NOTICE TO CONTRACTOR
 All construction shall comply with current NC Building Codes and is subject to field inspection and verification.
 APPROVED
 Unlimited liability only within
 Permit holder responsible for
 full compliance with the code.
 02/07/2022

Teralyn II GR

Triangle Home Pros, LLC
 6312 Lauraca Lane
 Fuquay-Varina, NC 27526

**FRONT ELEVATION**  
1/4" = 1'-0"

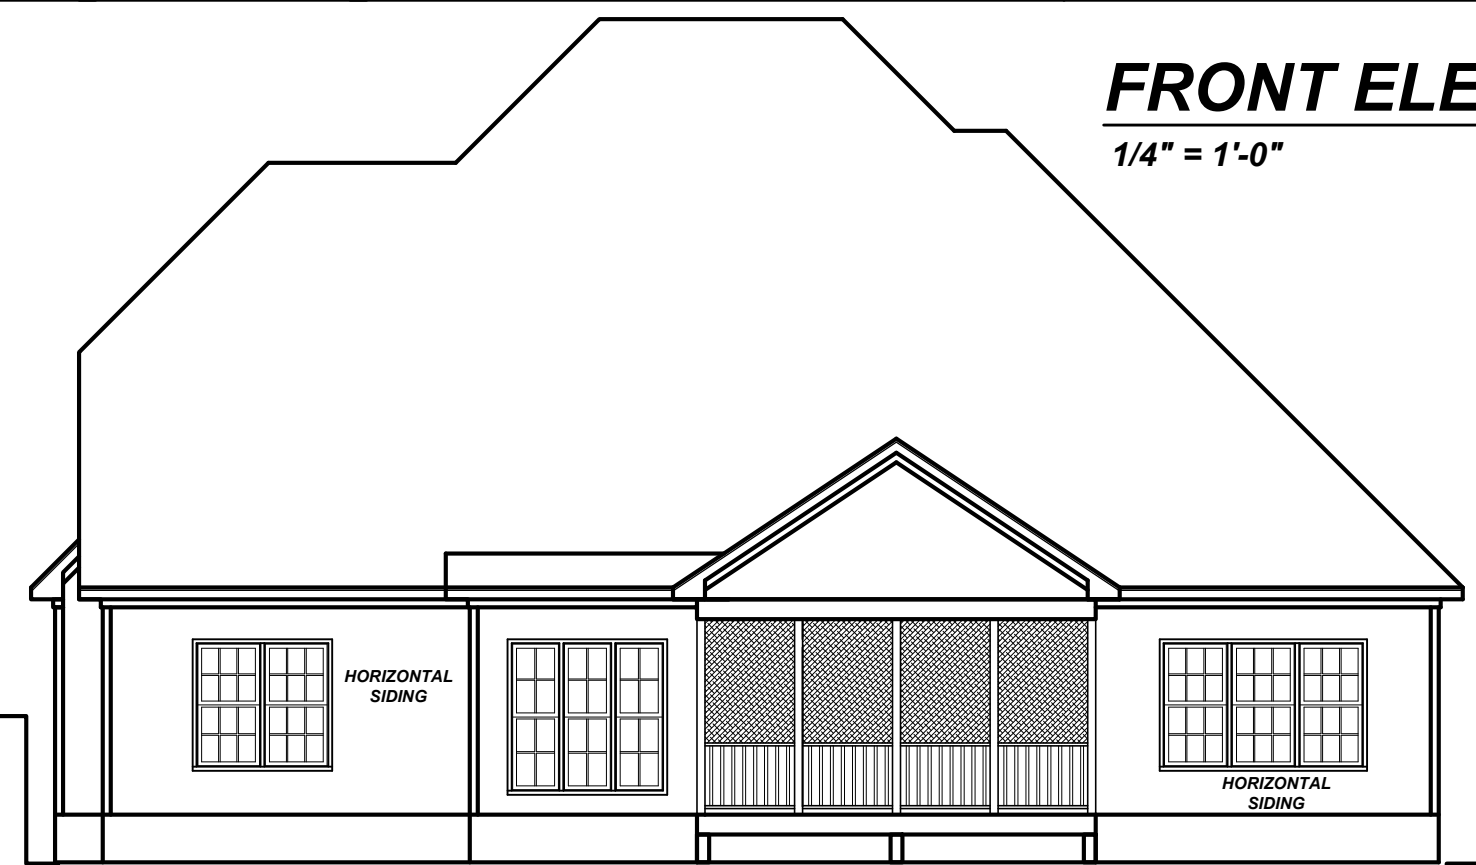
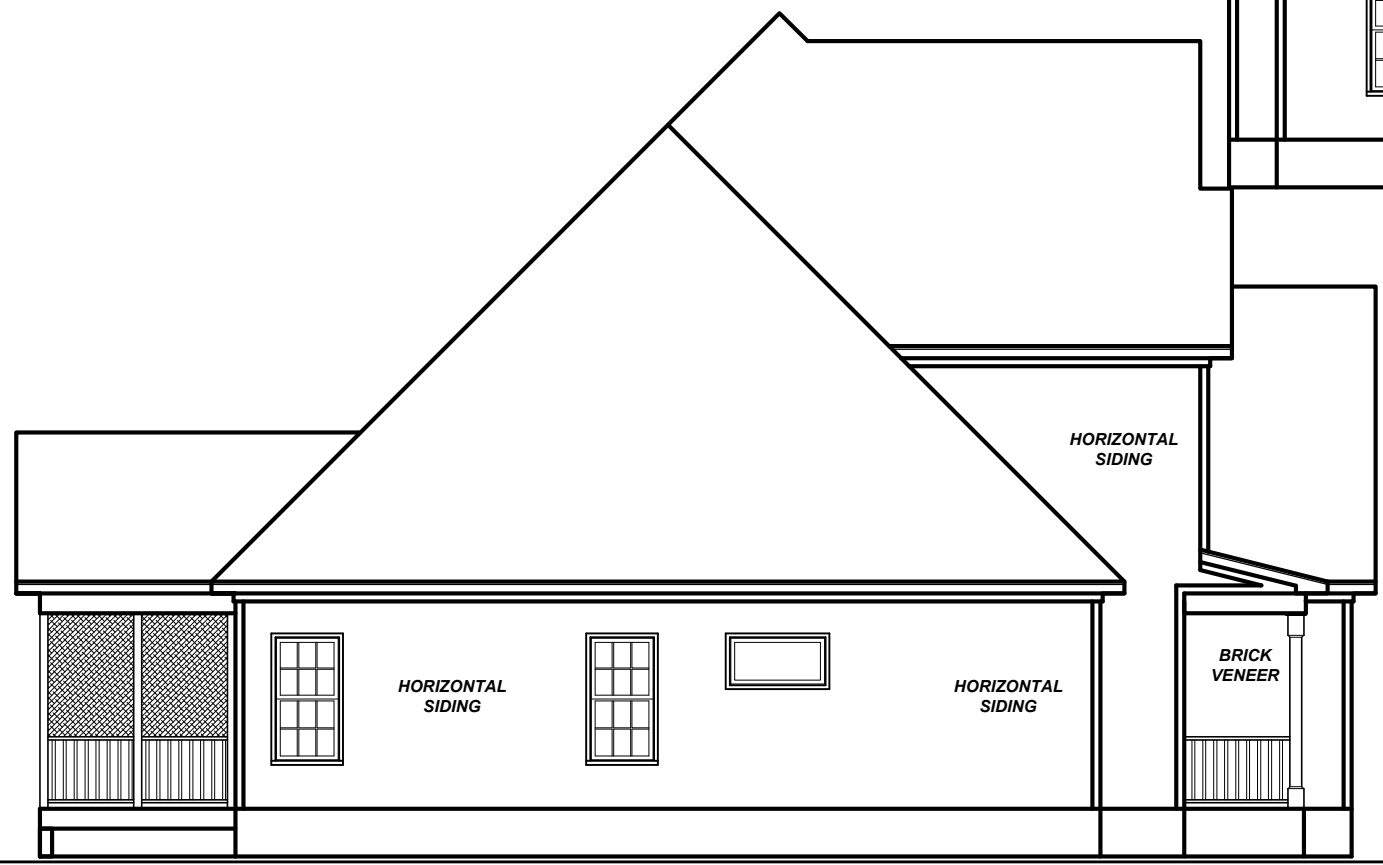
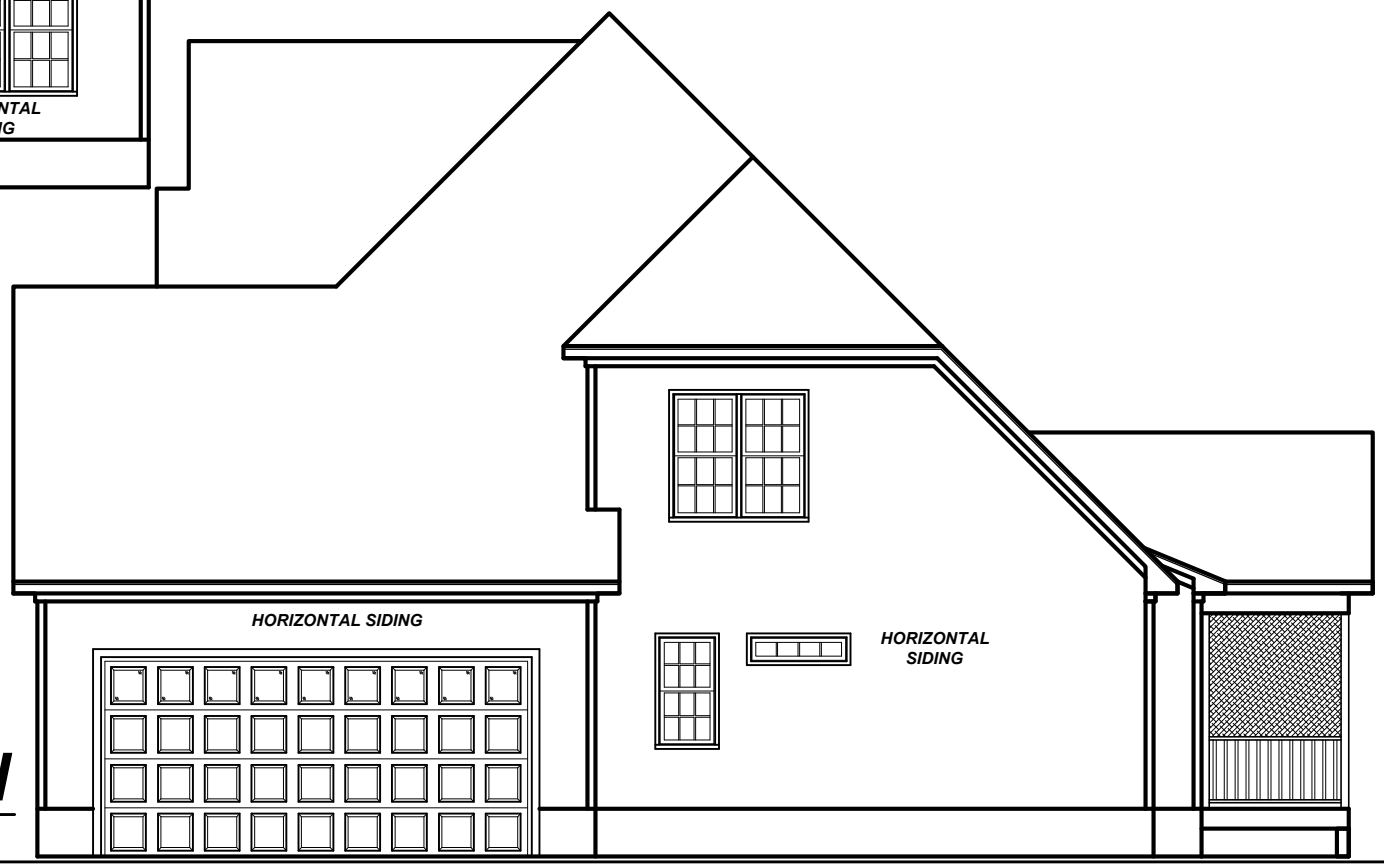
Field verify upstairs egress window sizes
